From: ENVU Biodiversity and Land Use
Sent: 17 June 2025 08:58
To: Planning ContactCentre
Cc: Danielle Cooper
Subject: 2025/91488 at location Barnside Farm, Barnside Lane, Hepworth, Holmfirth, HD9 1TN

BLOCK PLAN 1:200

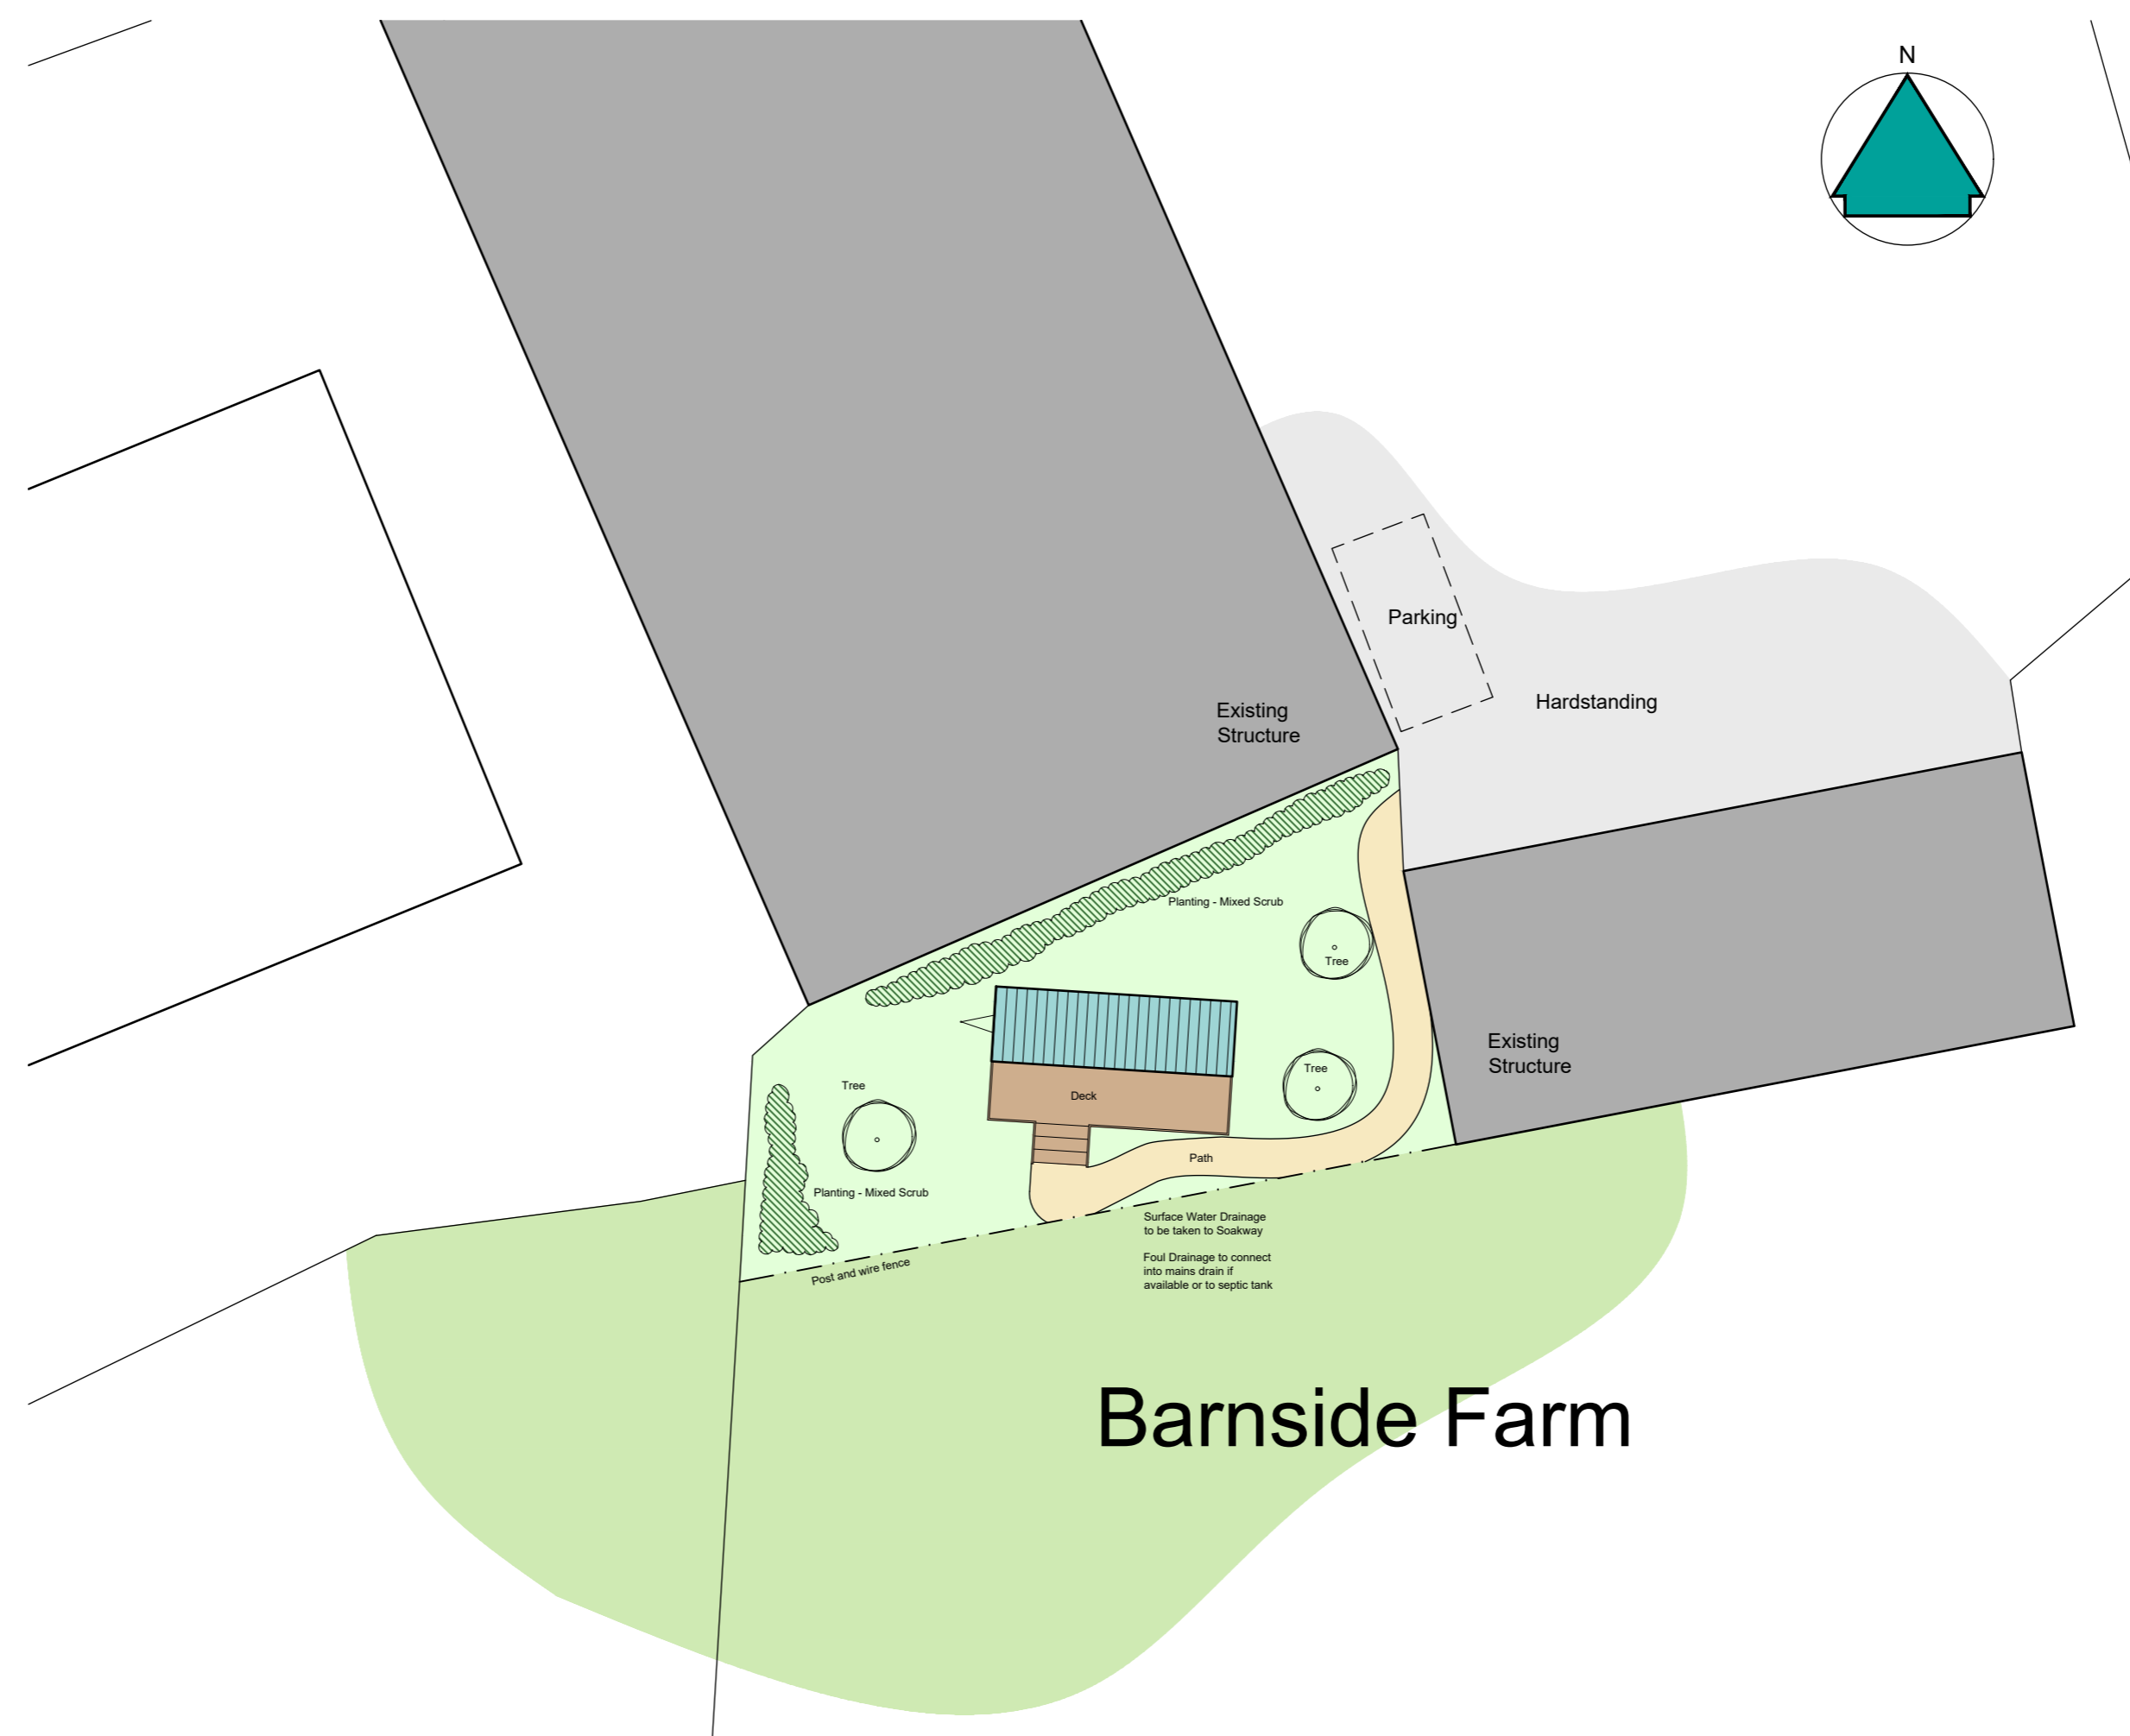
There are priority habitats for woodland and grassland within 500m of the site. There are a series of mature trees to the southwest of the site, with good connectivity to the wider surrounding habitats. A watercourse is within 200m of the site. The barns have not been considered to ensure no impact to potential roosting bats or nesting birds.

Further information is required prior to decision. Several records for protected and priority species and habitats are present within 1km of the site. A Preliminary Ecological Appraisal is therefore required prior to decision to assess the site habitats, the likely presence of protected and/or priority species, and the value of site habitats to protected and/or priority species.
